Application M/56/15/HH

31 Sea Way, Middleton-On-Sea, West Sussex, PO22 7RZ

We object to the plans under consideration at the above property. We moved to the estate in 1999 and have seen this house which is directly opposite ours change from a small, character cottage to an ever expanding structure, most of which is 'new build'. It is the equivalent of having two properties on the original plot. The character of the road at this point has already been unacceptably altered, including the addition of what seem to be large UPVC gates, and further overdevelopment must not be allowed.

Proposed Floor Plans
- Ground Floor
- First Floor
- Roof Plan

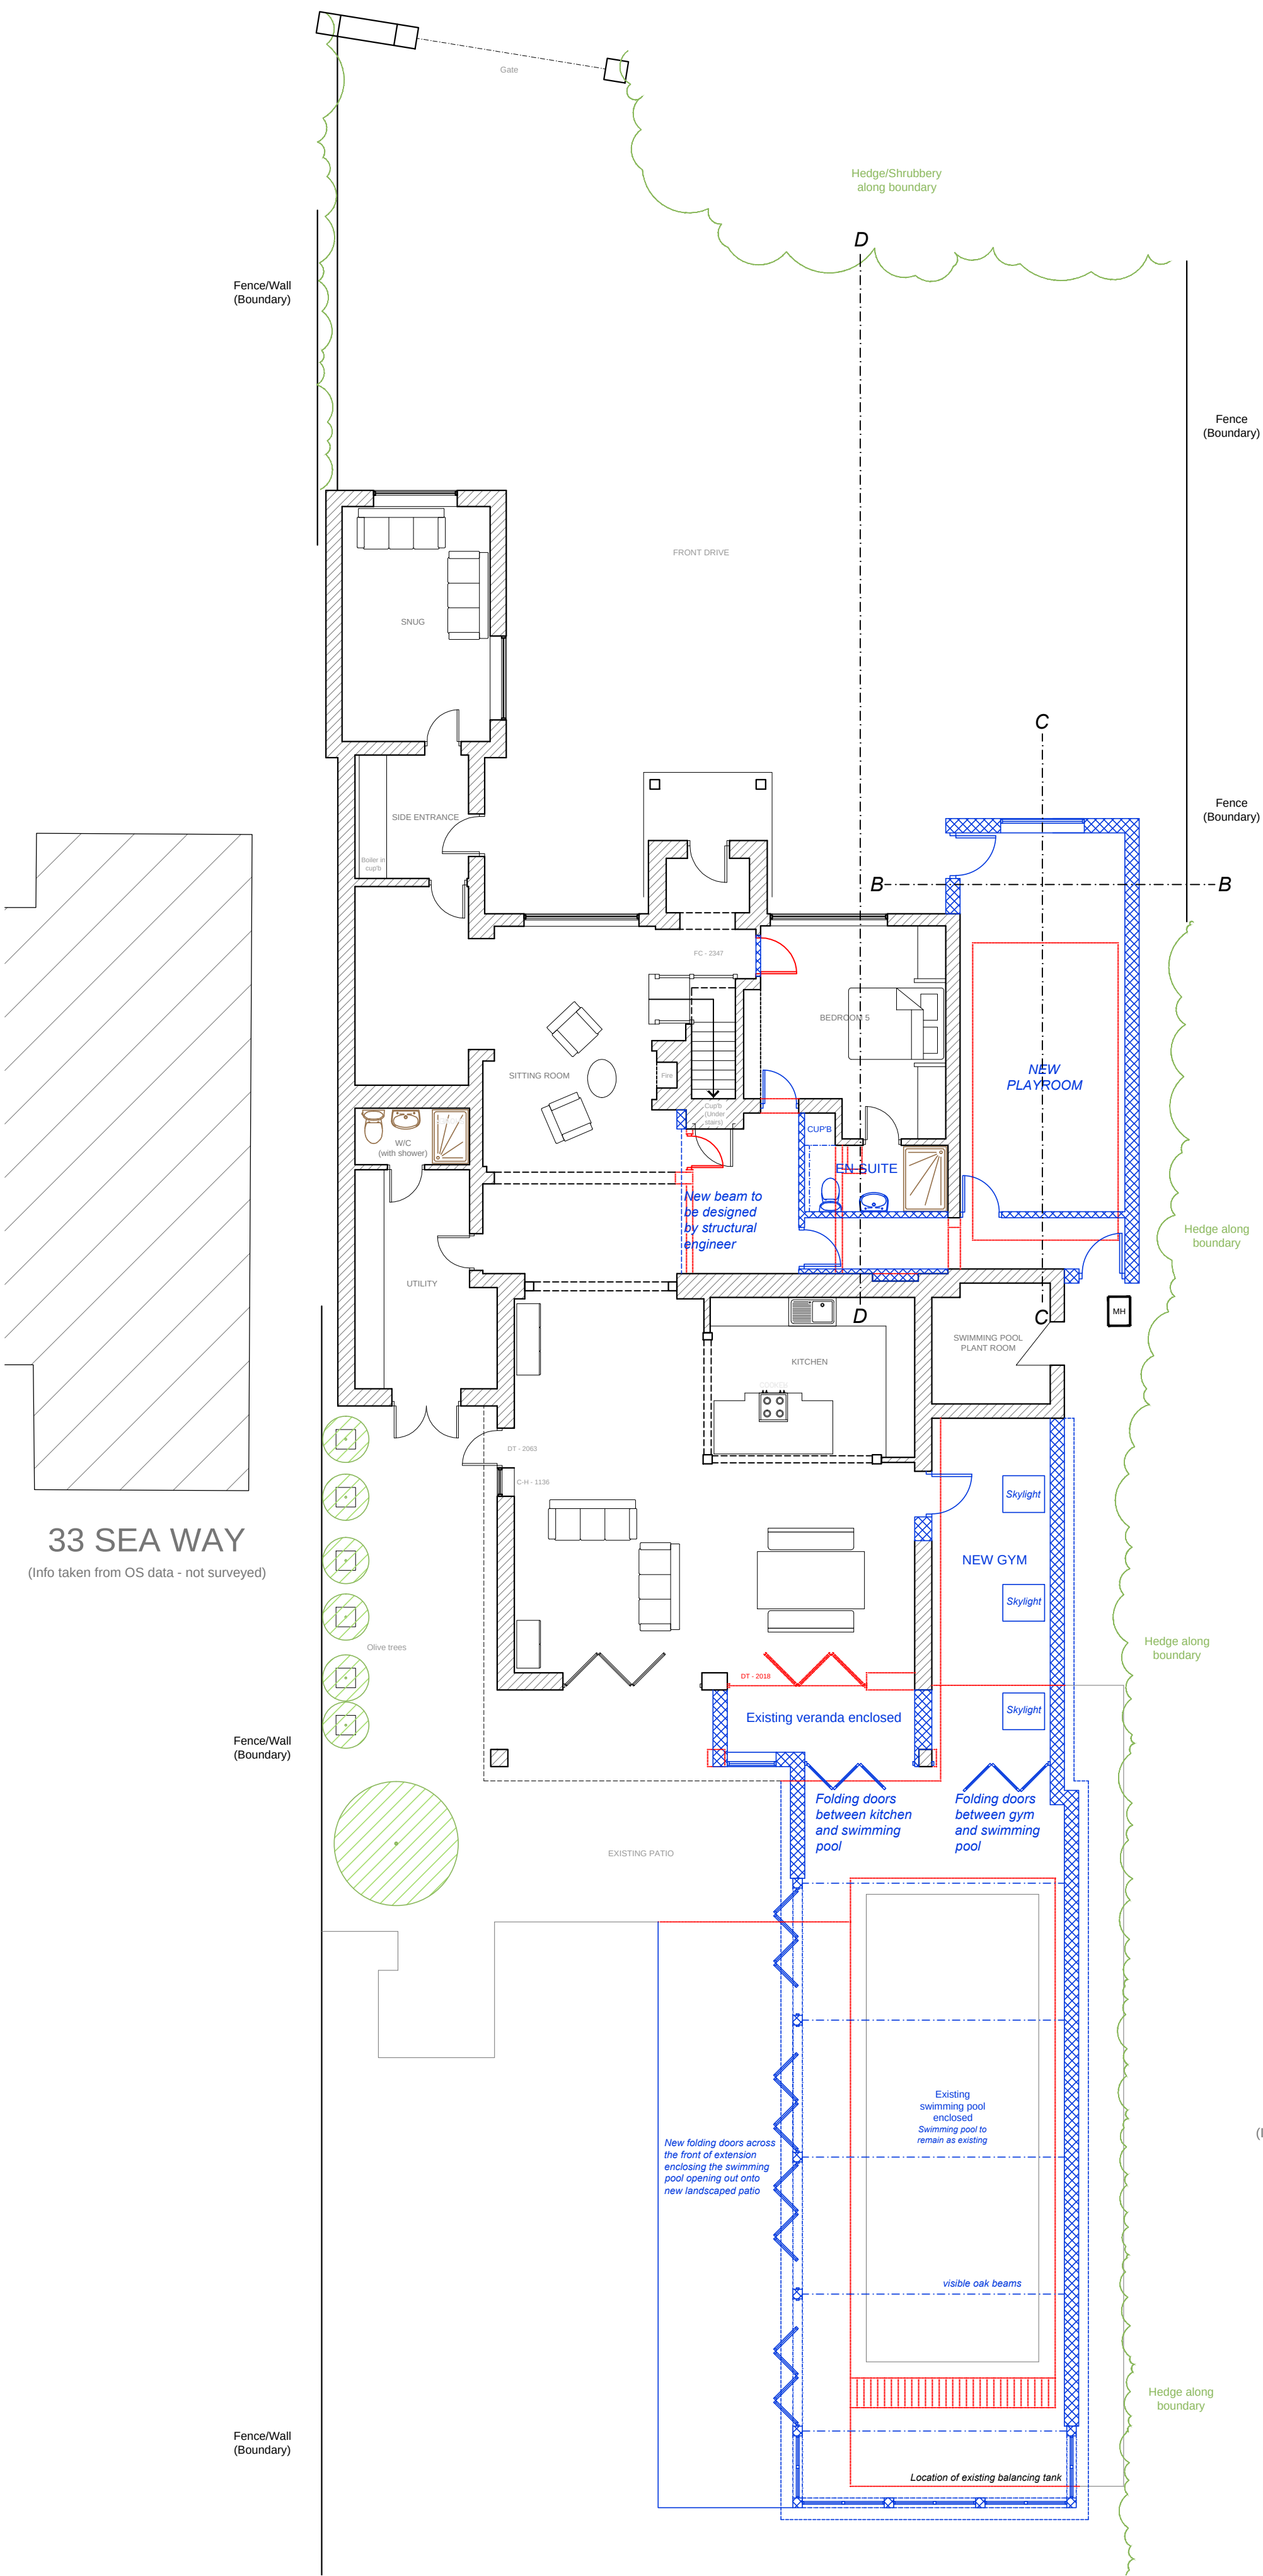
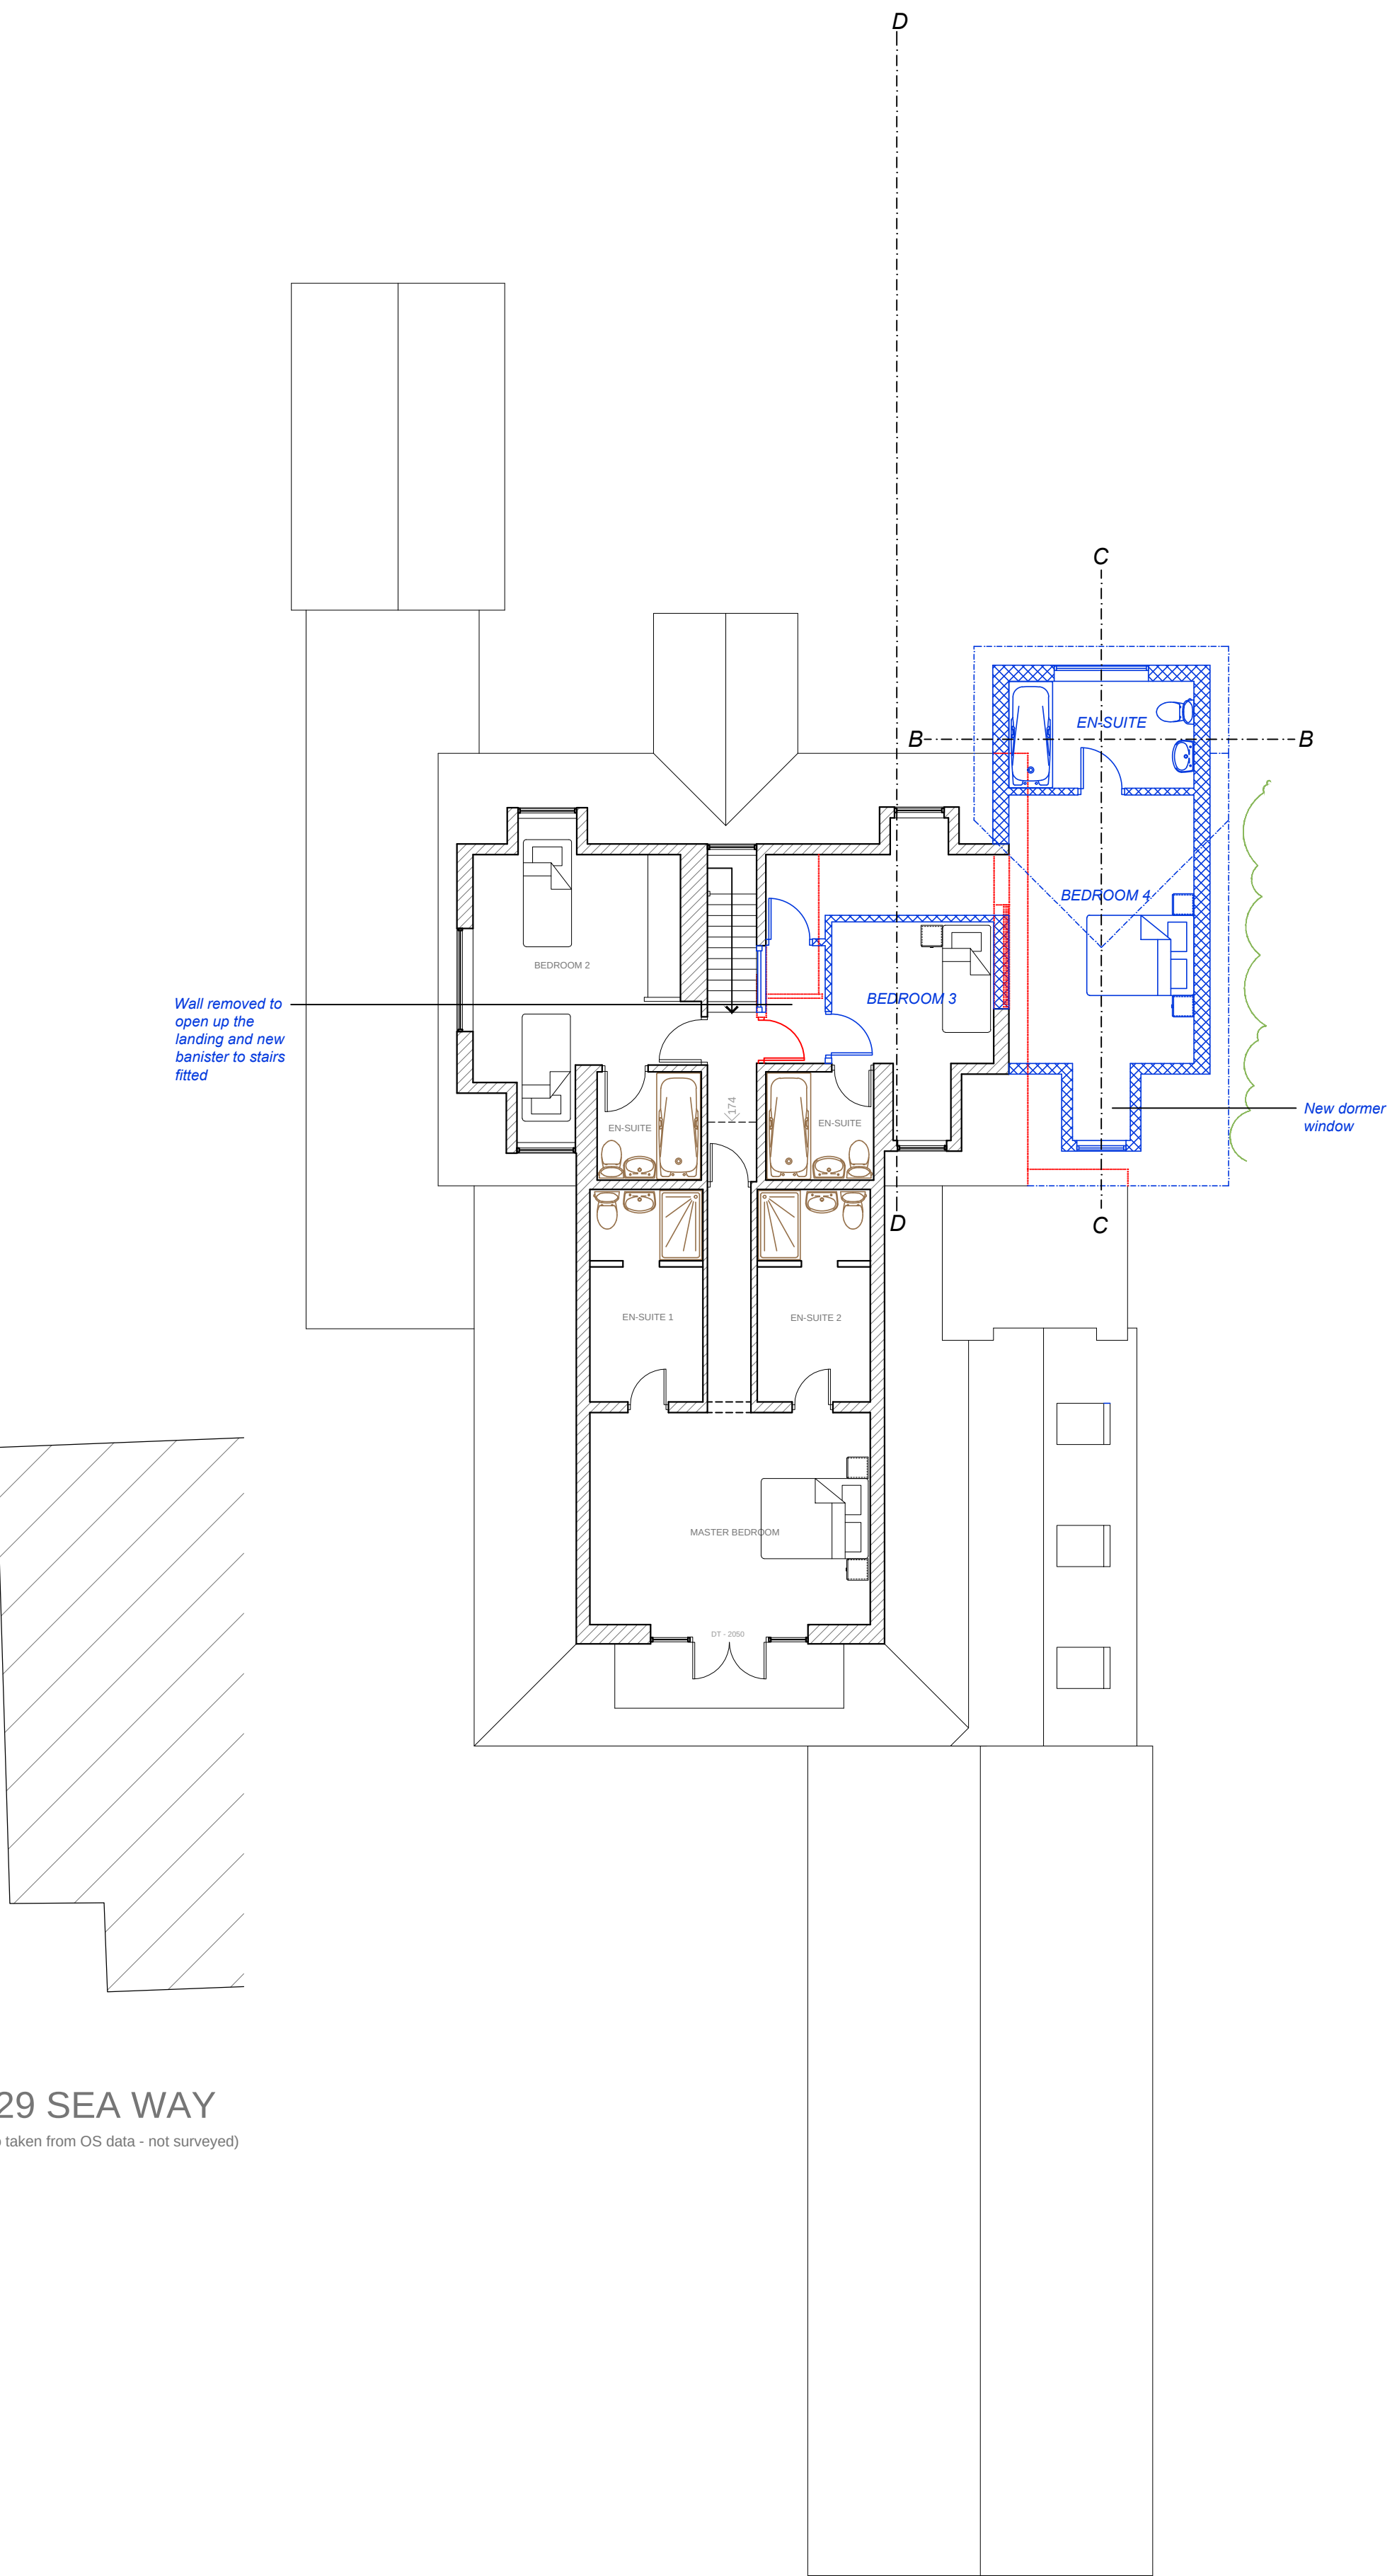
We find the proposed garage particularly disturbing. The plans blatantly breach the 'building line' adage and would result in the property being closer to the road than any other property on the estate. Surely this is not acceptable on this ground alone?

The proposed extension will be overbearing to the neighbouring property. The gap between the two is less than the accepted standard given the roof overhang. This will be evident to a planning committee viewing the site and must be taken into account. A previous application was made, I believe, by these residents to make a similar extension to the West of the property and was turned down on these grounds. Reference needs to be made to objections made at that application and considered in relation to trying to do the same thing on the other side.
